**WELWYN HATFIELD BOROUGH COUNCIL
EXECUTIVE DIRECTOR - PLANNING, PUBLIC PROTECTION AND GOVERNANCE**

Application No: 6/2018/0501/HOUSE
Location: 12 Coulter Close Cuffley Potters Bar EN6 4RR
Proposal: Retention of raised decking area and access steps
Officer: Mr Richard Sakyi

Recommendation: Granted

PROJECT TITLE		12 Coullier Close	
DRAWING TITLE		Proposed Plan and Elevation	
DWG STATUS		Planning Approval	
DRAWN	FILE	DATE	REVISION
CHECKED	JOB NO.	SCALE	DWG NO.
		1/100 - 1/50	CC - 001/2018

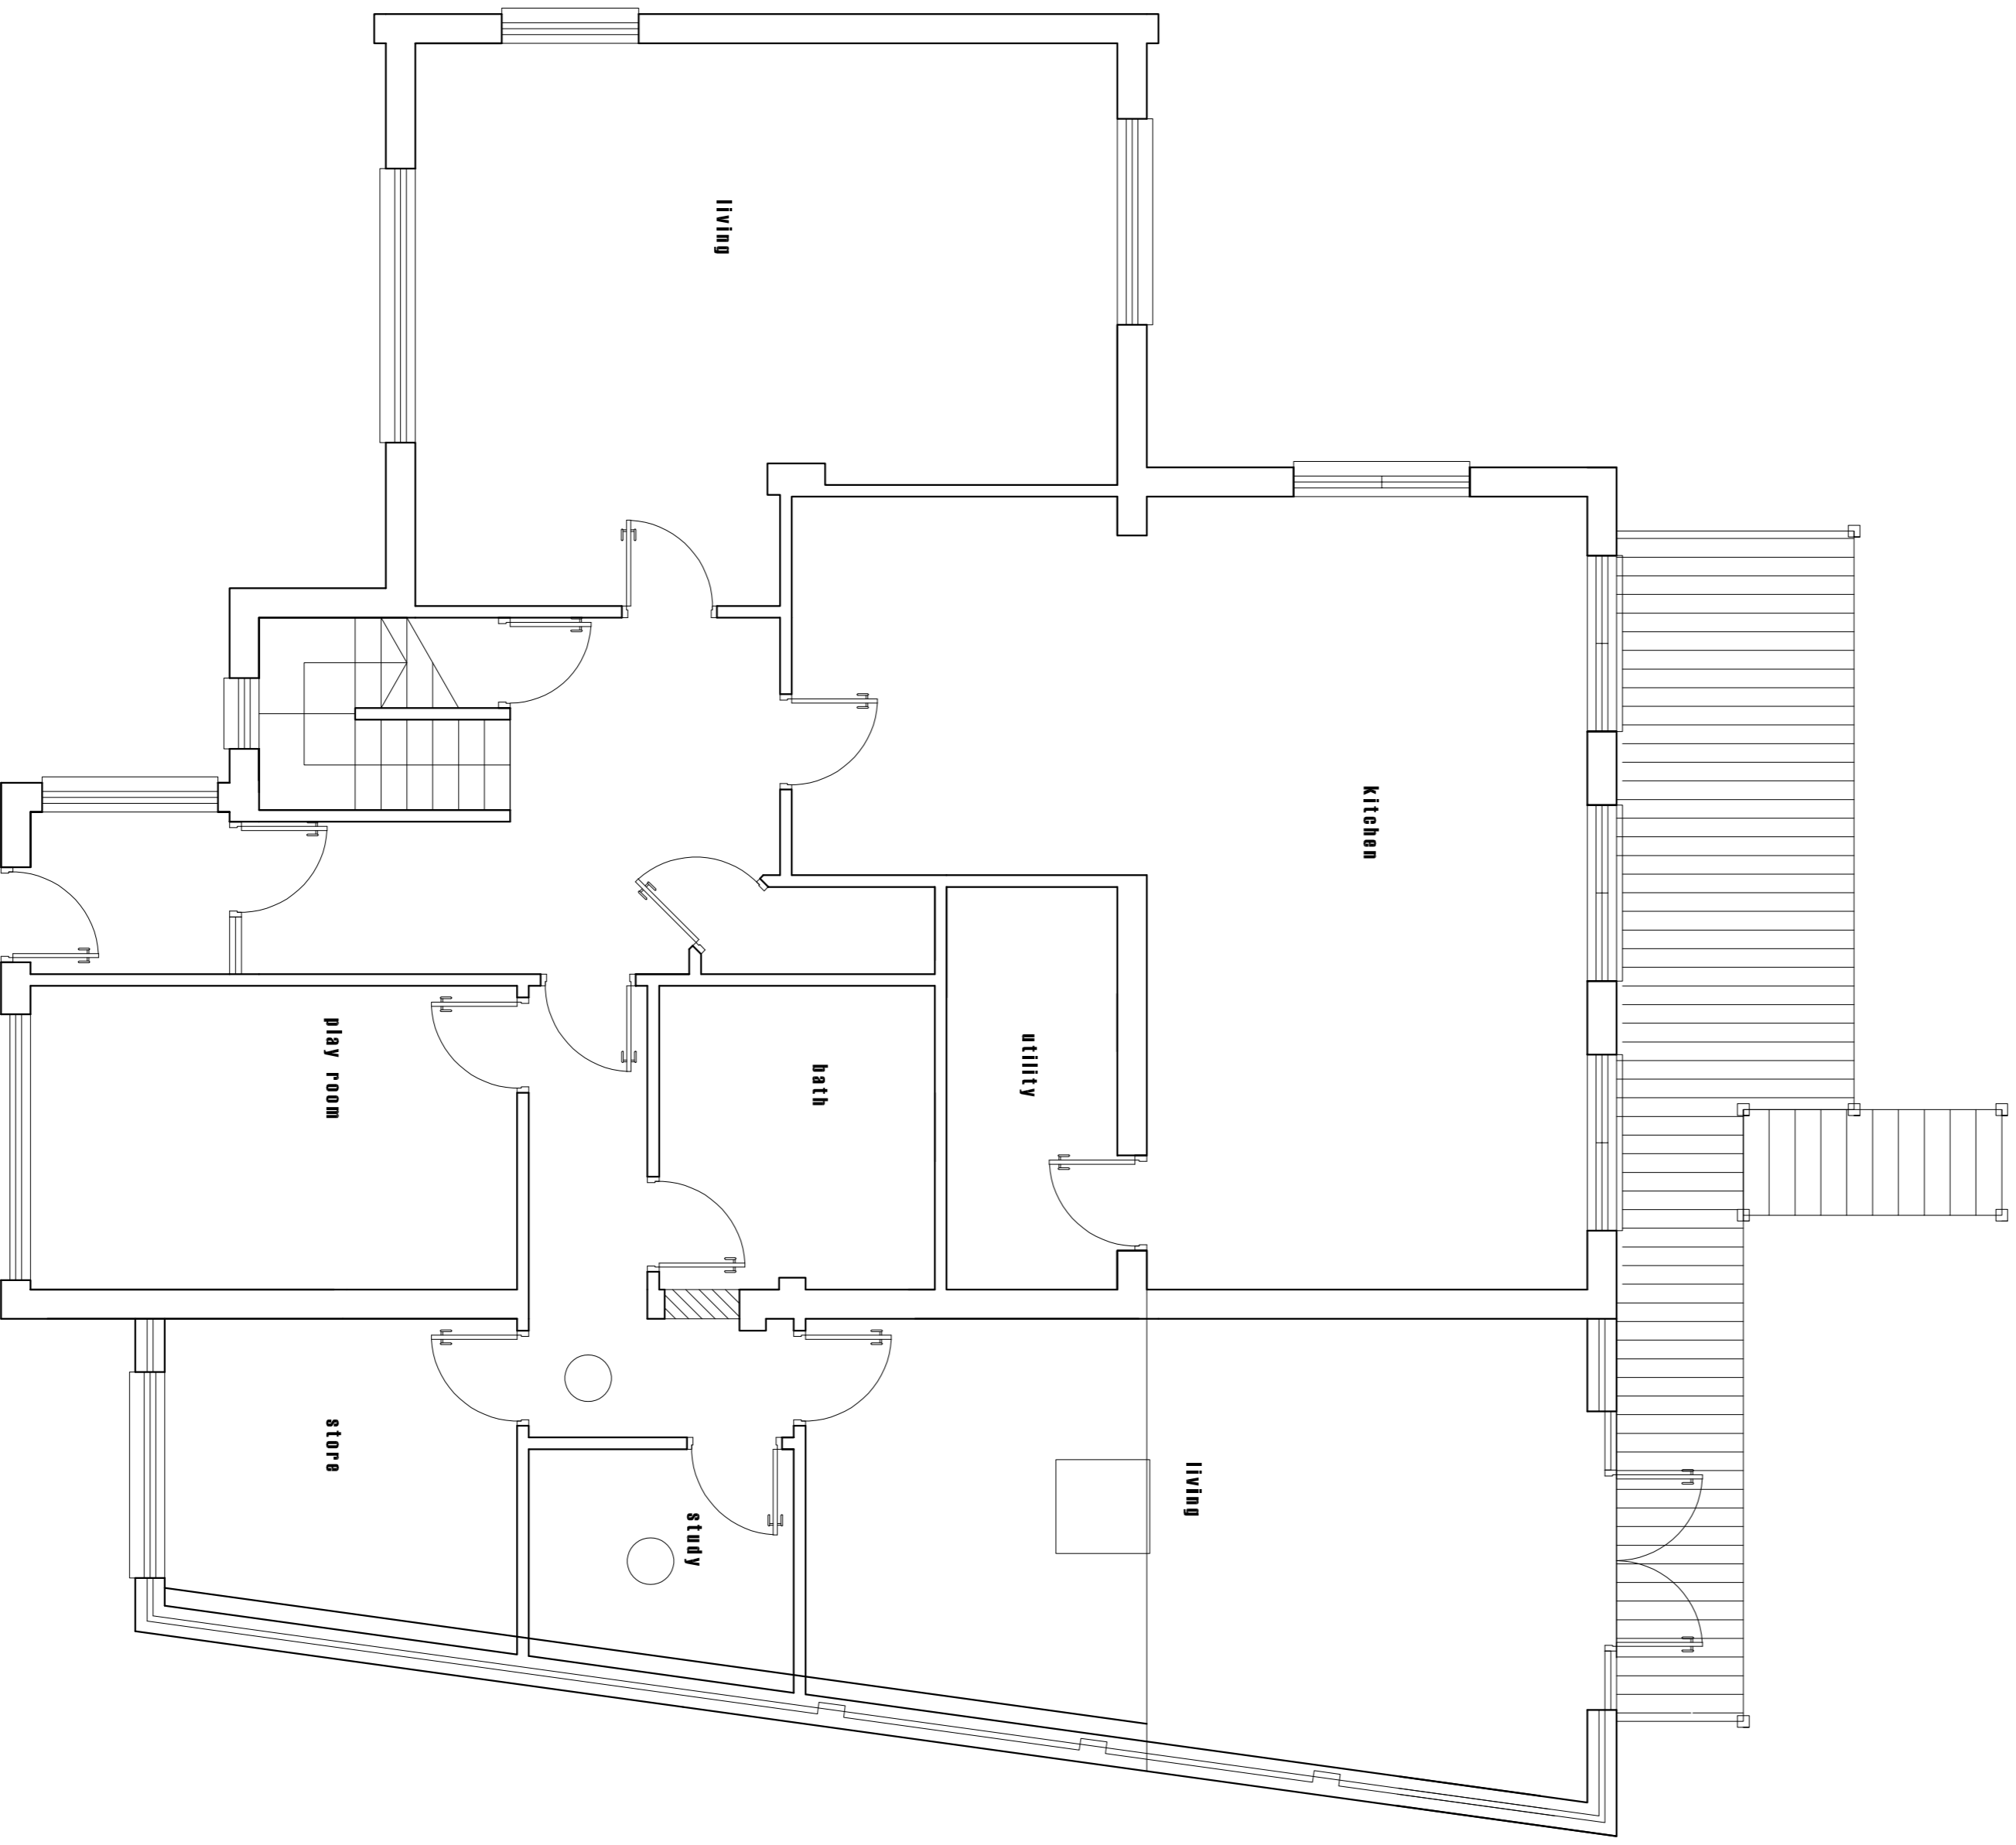
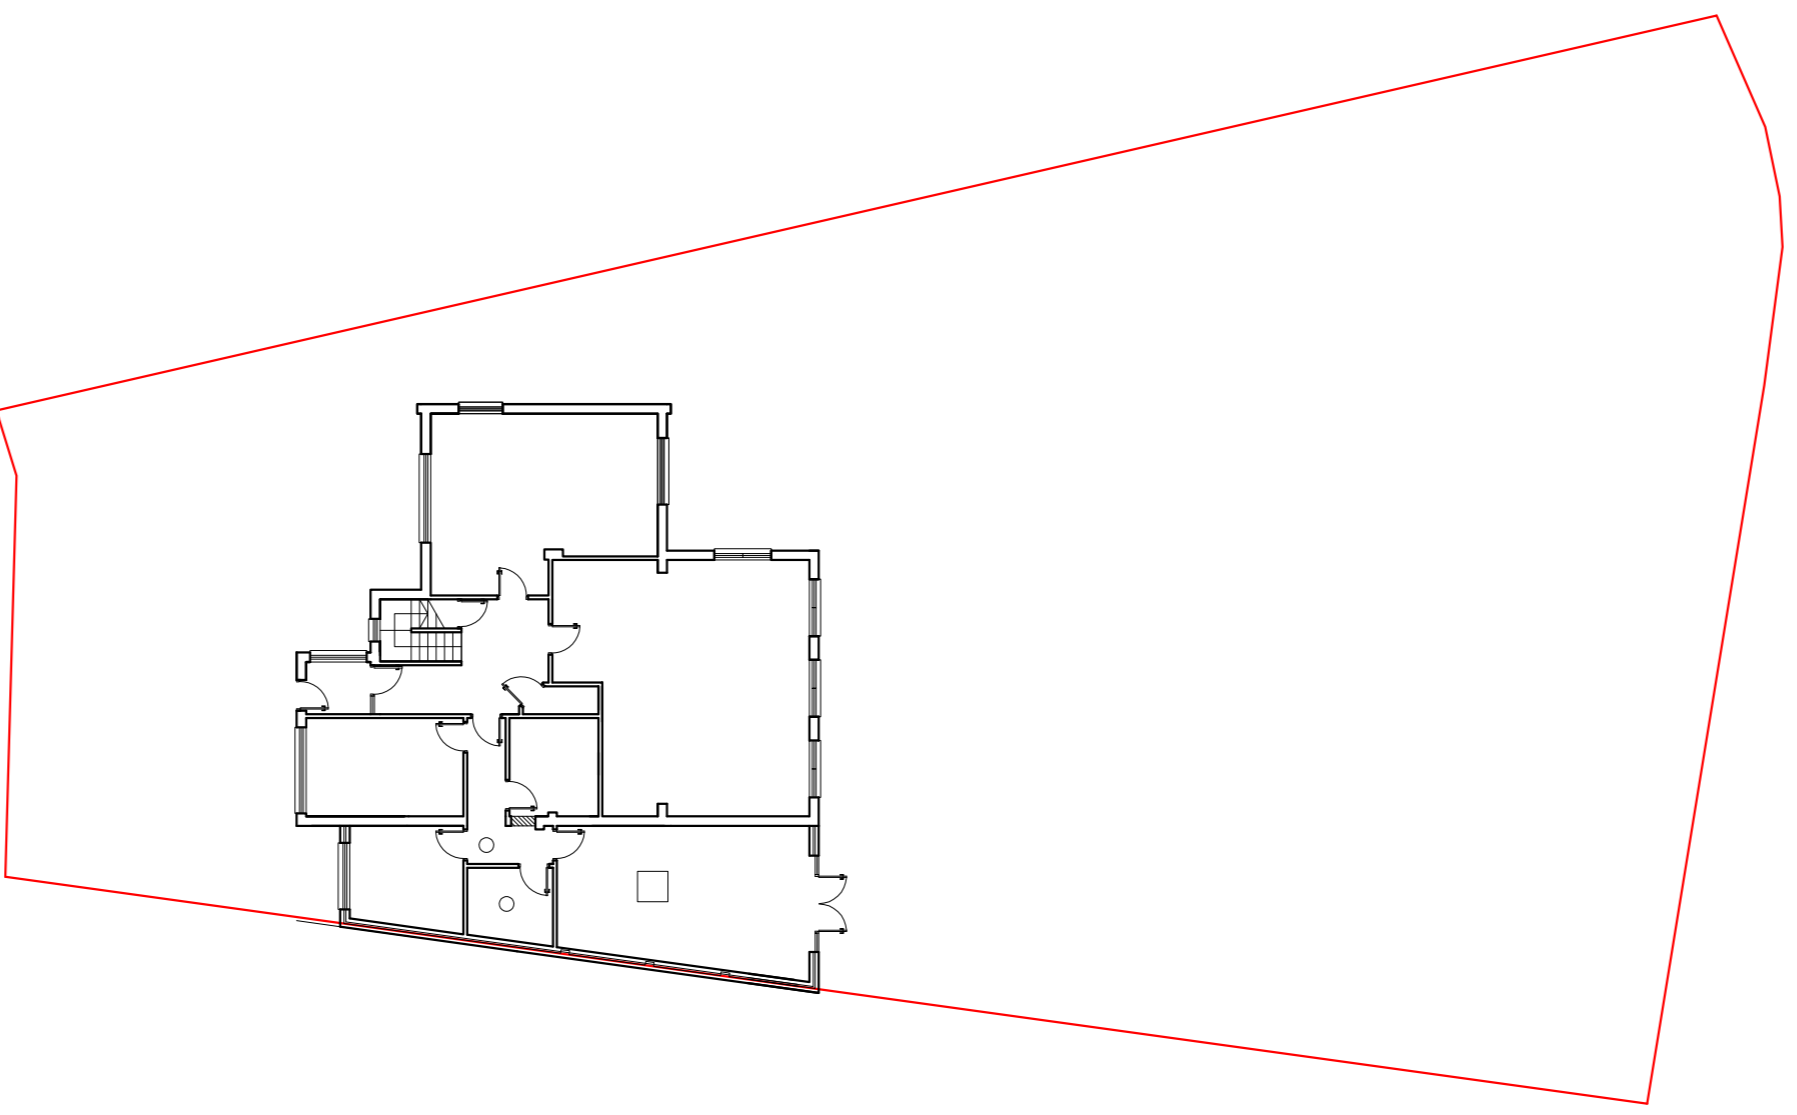
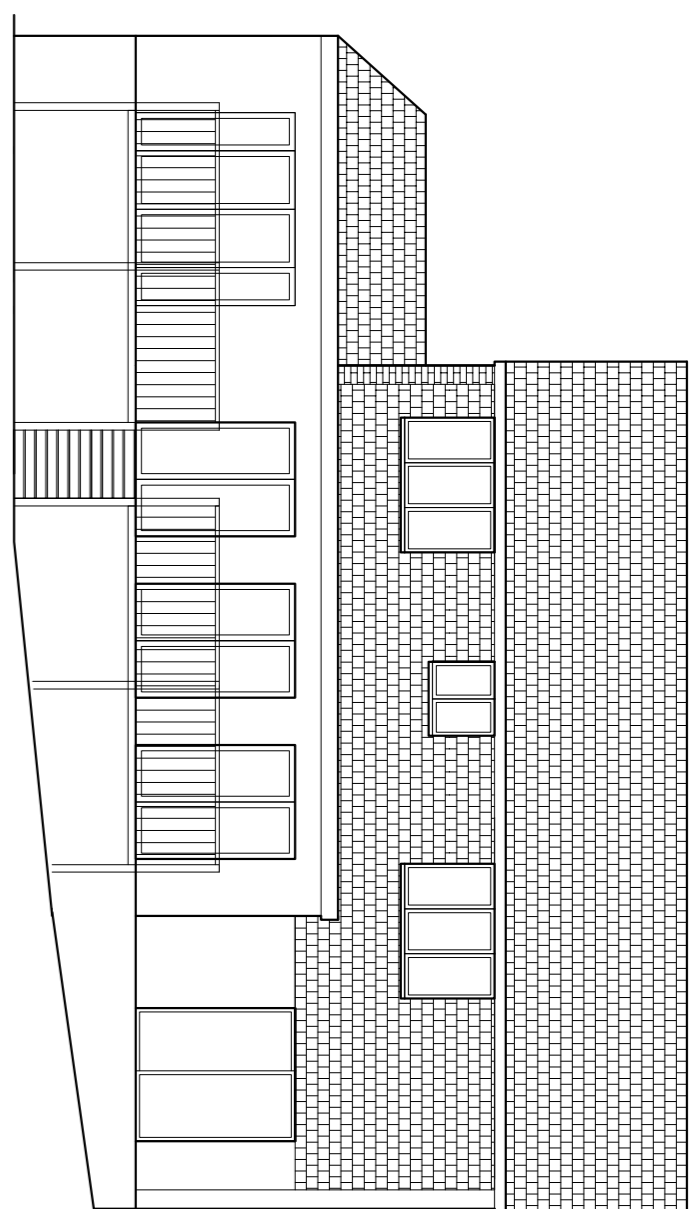
Main Issues	
Impact on neighbours	<p>The main issue in this case is whether the decking and steps which are in place have detrimental impact upon those living nearby by reason of overlooking and overbearing impact.</p> <p>The existing decking area is in a form of L-shape and measures approximately 10.7m long, 2m deep at its deepest end and 1.0m deep close to the boundary with number 10 Coulter Close. The decking is approximately 1.4m high when measured from the ground level with access steps of similar height. The rear garden of the property slopes steeply towards the rear of the site. The site is enclosed by a boundary wall of approximately 2m high along the shared boundary with number 10 Coulter Close and tall trees and vegetation along the boundary with number 14 Coulter Close.</p> <p>Due to the sloping nature of the rear garden, it is clear that the decking area provides a solution for the use of the amenity space/area close to the rear of the dwellinghouse. The properties to either side of the application property are detached houses with similar long and steep sloping gardens with adequate screening along the shared boundaries.</p> <p>Whilst it is clear that some form of overlooking does occur if one is standing on the decking close to the shared boundary wall with number 10 Coulter Close, I have come to the conclusion that in this particular circumstances, this is not unacceptable by virtue of the height of the decking, height of the existing boundary wall, location and distance from the adjoining property. Further, the depth of the decking, where it is closest to the boundary, has been kept to a minimum and appears to serve simply as an access to the closest set of French doors. Whilst the structures have a somewhat cluttered appearance, it is not considered to be overbearing on the amenities of the adjoining neighbours and not harmful to the character and appearance of the area.</p>

Conclusion	
<p>The development is considered acceptable and complies with the relevant policies of the adopted Welwyn Hatfield District Plan and the guidance in the National Planning Policy Framework 2018.</p>
